Your Ref: OWPC3395
Our Ref: A/99/14/HH 20-07-2014
Please ask for:
Mr D Sullivan

Removal and reconstruction of part of the front boundary wall (resubmission following A/46/14/HH). This application affects the character and appearance of the Angmering Conservation Area.

2 Woodford Villas High Street Angmering

DRAWING TITLE
PROPOSED FRONT BOUNDARY WALL
ELEVATIONS, PLAN AND SECTION

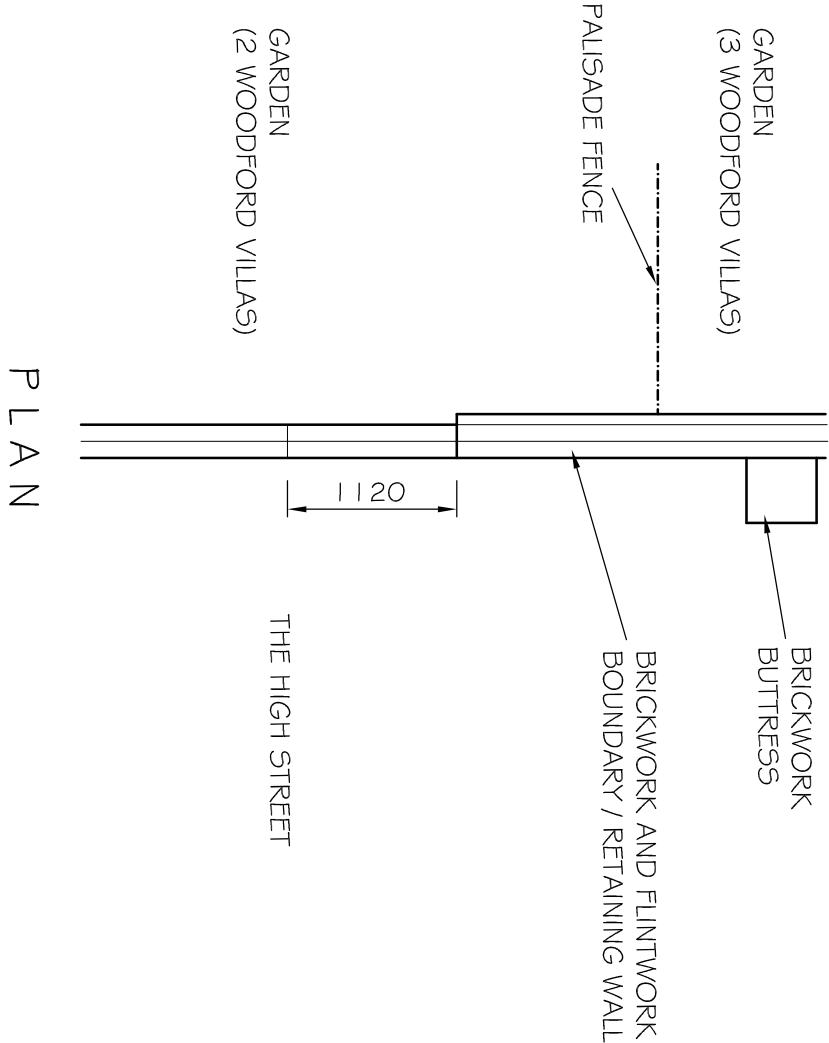
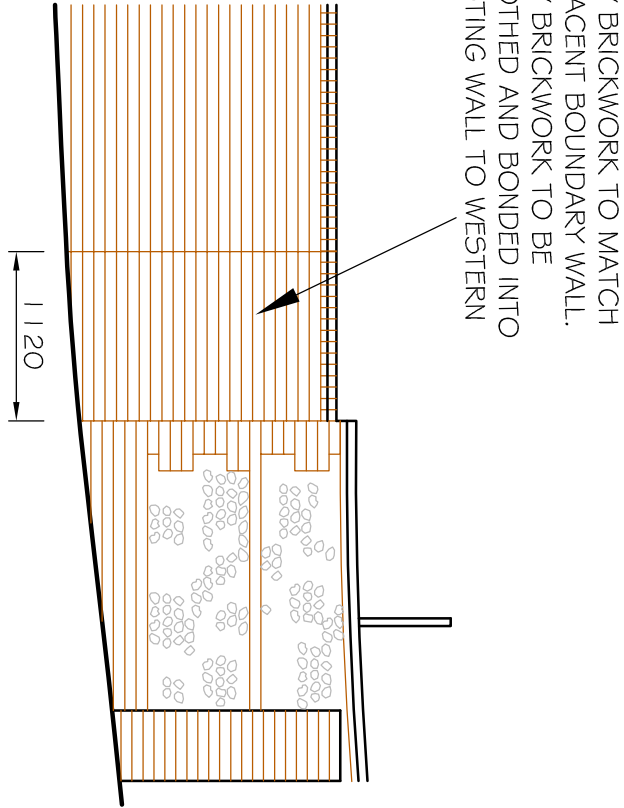
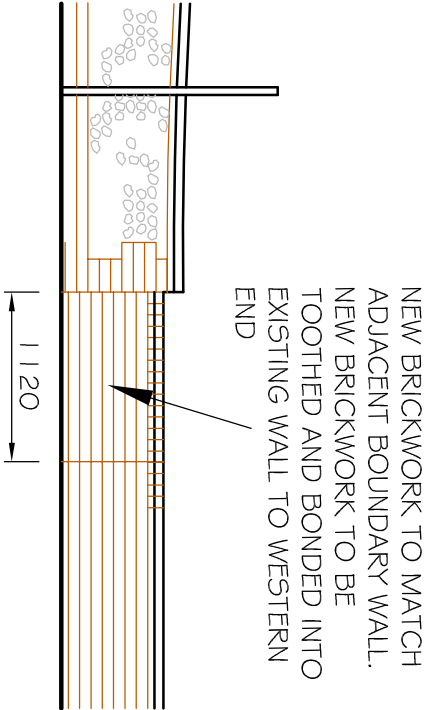
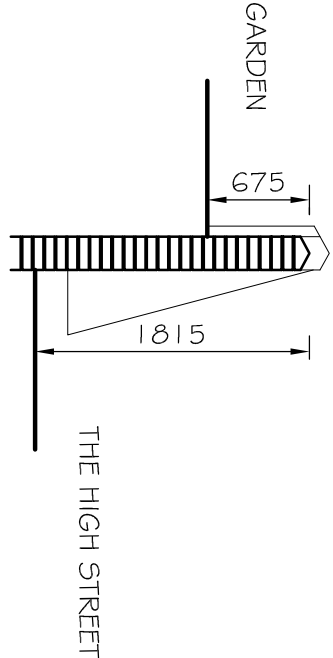
In addition, apart from the height of the wall being too great, the wall now blocks what was an historic and in keeping with a conservation area, access to 5 additional properties. It has also been confirmed in writing by my solicitors (Bennett Griffin) as a right and proper access at the point of wall entry to my property.

Any construction, using any materials would still be out of place with the original character of historic access and ride roughshod through the planning regulations.
